## **Bicester Delivery Team Comments: 19/01036/F Bicester Eco Town Exemplar Site Phase 2 Charlotte Avenue Bicester (17/06/19)**

The following sets out the comments on this planning application from the Bicester Delivery Team.

**APPENDIX 5**  
**AFFORDABLE HOUSING PLAN**

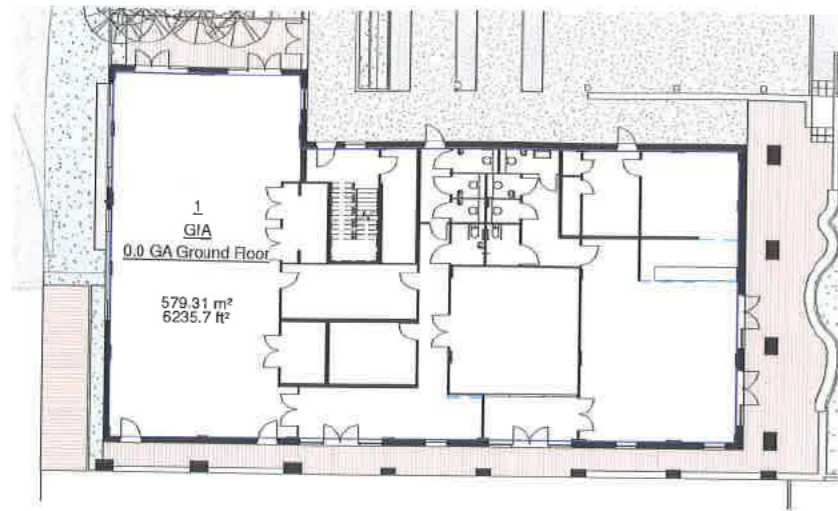
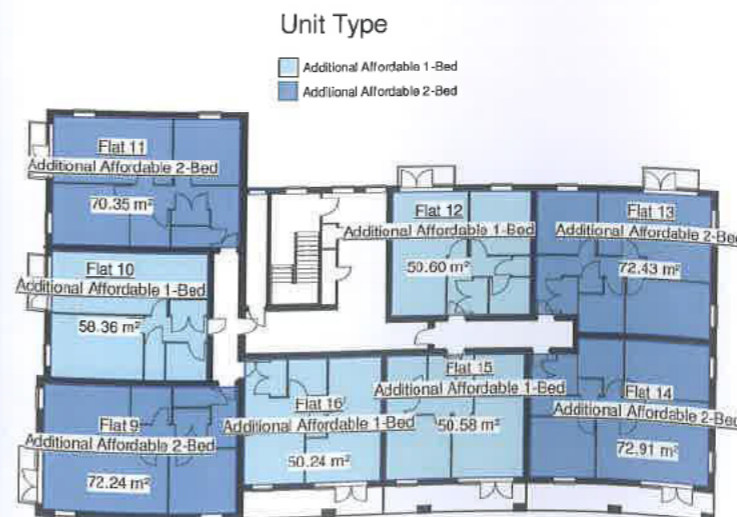
Another concern relates to the clustering of 38 affordable units proposed by the application. This is contrary to CDC's housing policy of allowing no more than 15 affordable units of mixed tenure in one place and will not support best planning practice of trying to achieve mixed and balanced communities.

**COMMUNITY SPACE AND CAFÉ AREA PLAN**

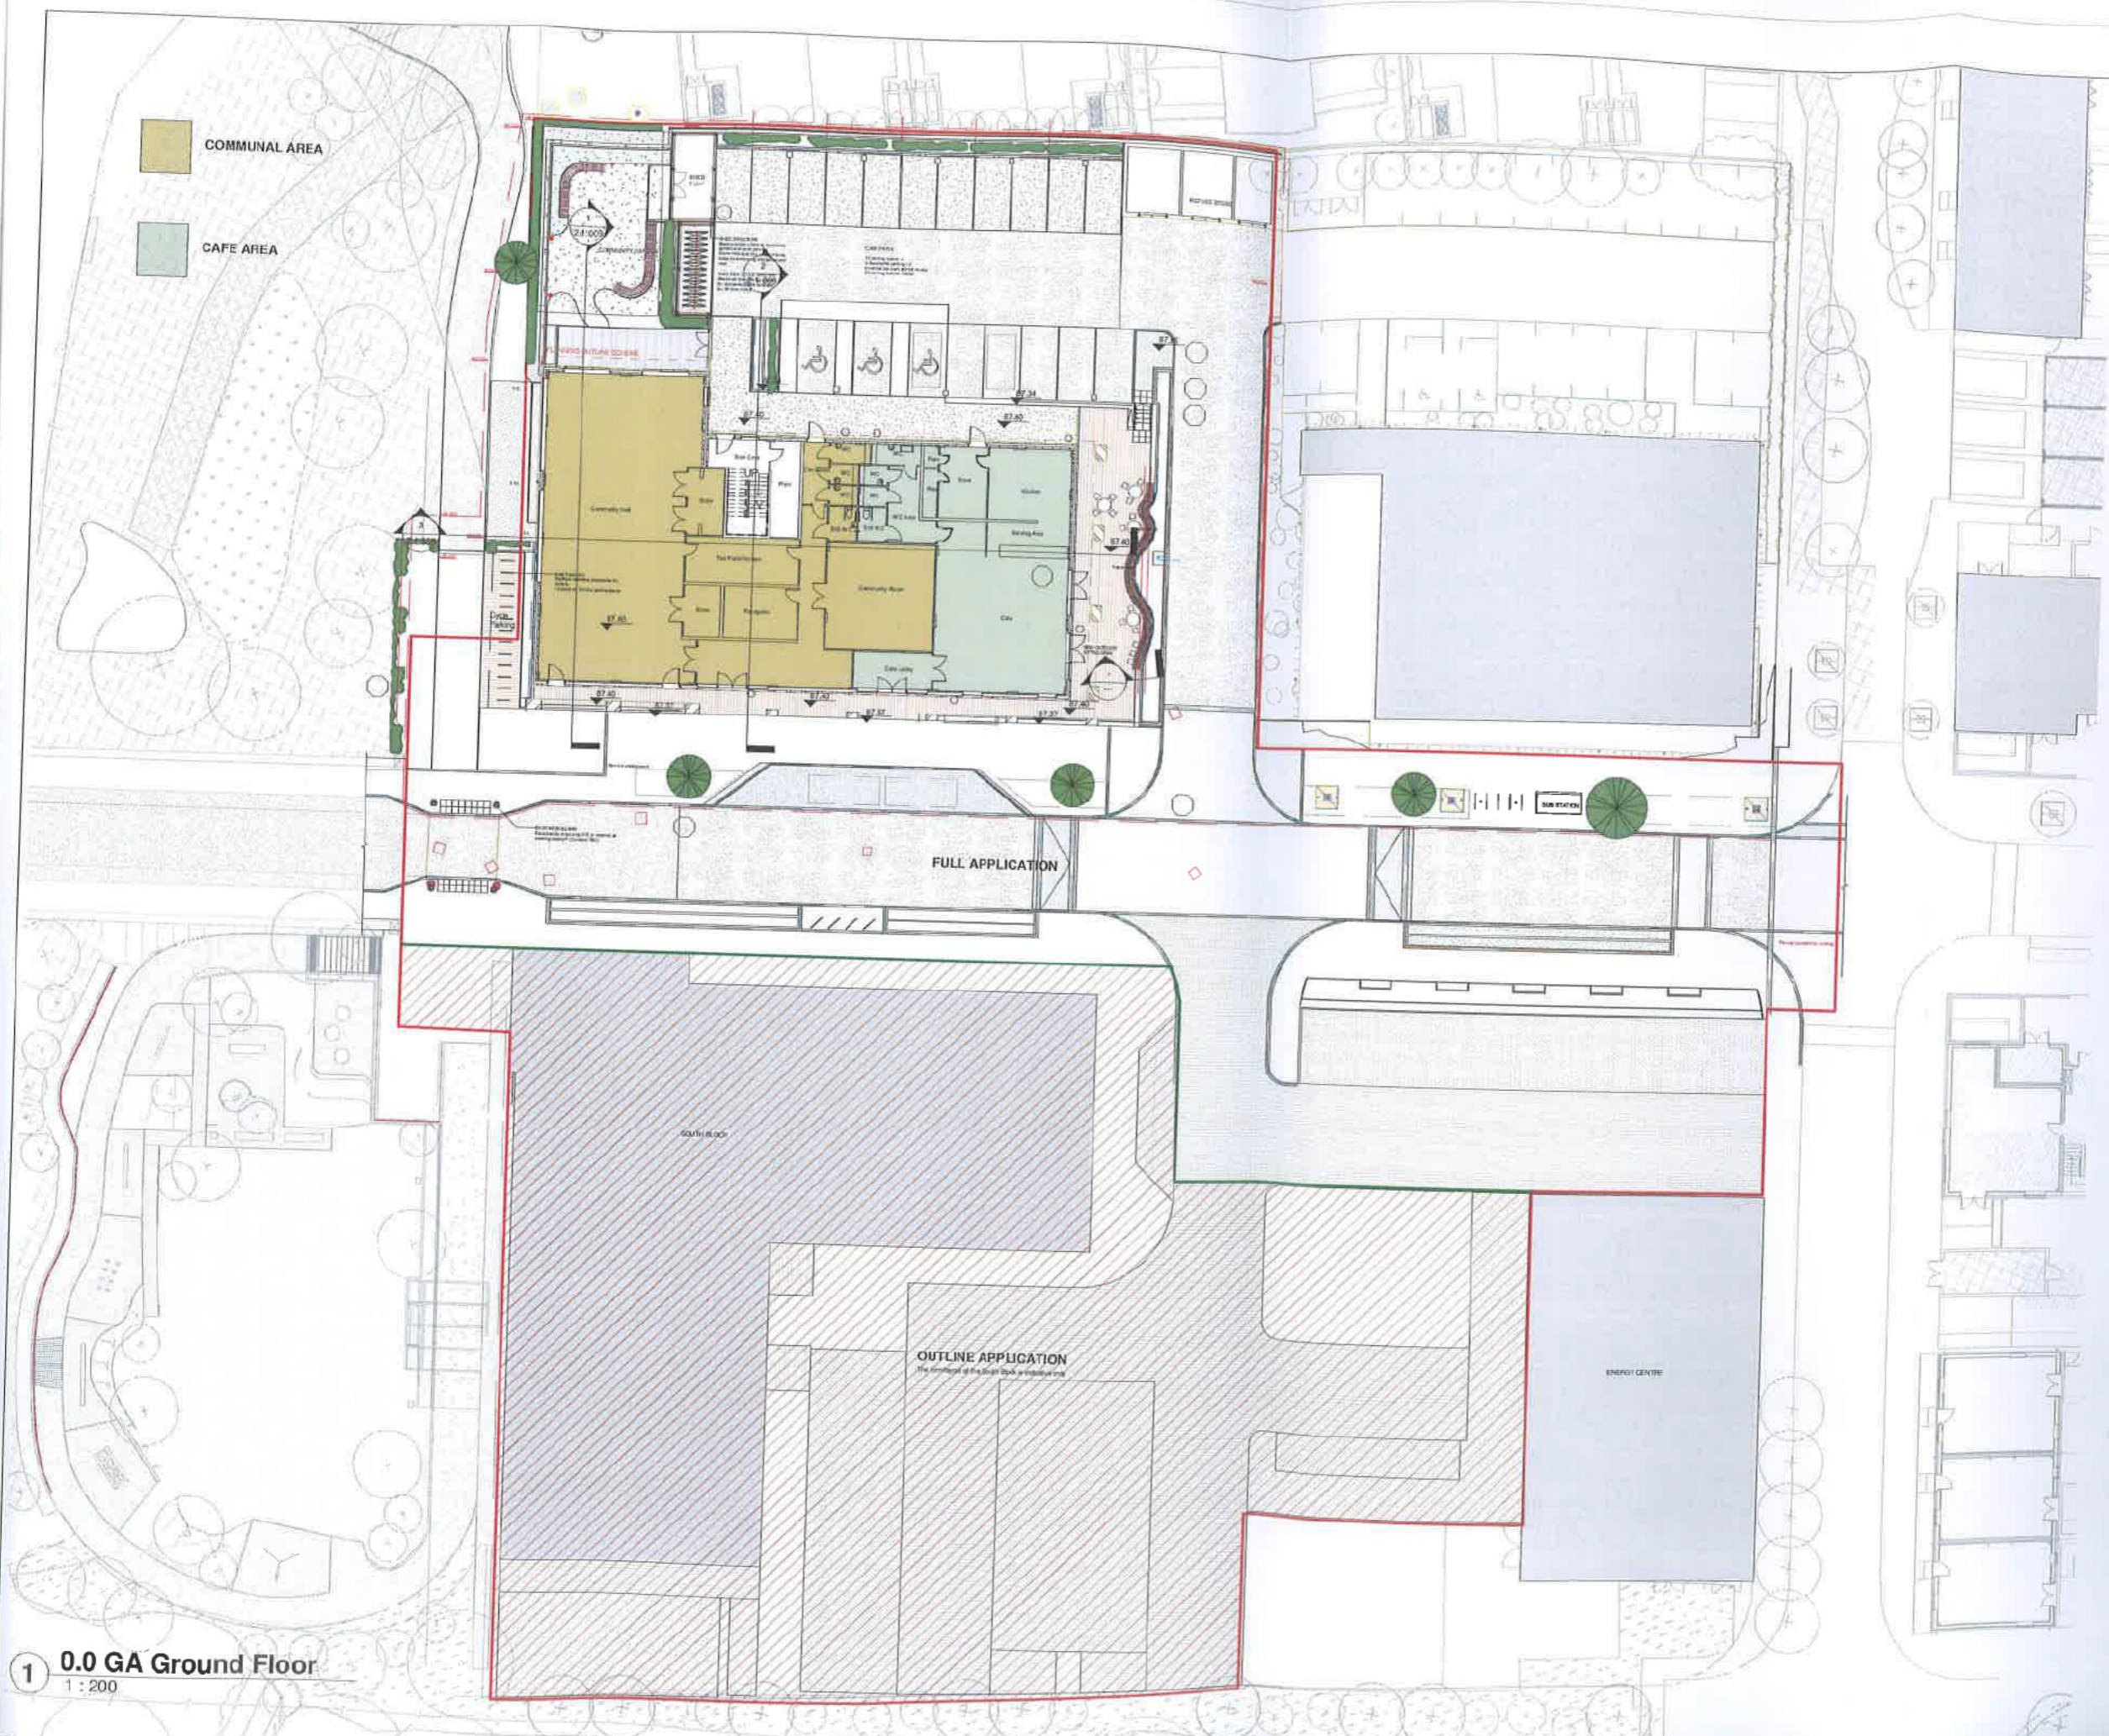
The suggestion contained in the DAS is that there will be a community space / café of 552 sq m, whereas the original approved floorspace for the hall was 350 sq m. Larger halls are more difficult / costly for local groups to manage. At the very least CDC should be seeking an additional commuted sum for management and maintenance of the hall if this larger size is acceptable in principle. On the plus side, it is welcomed that the hall is at ground floor level rather than at first floor as previously.
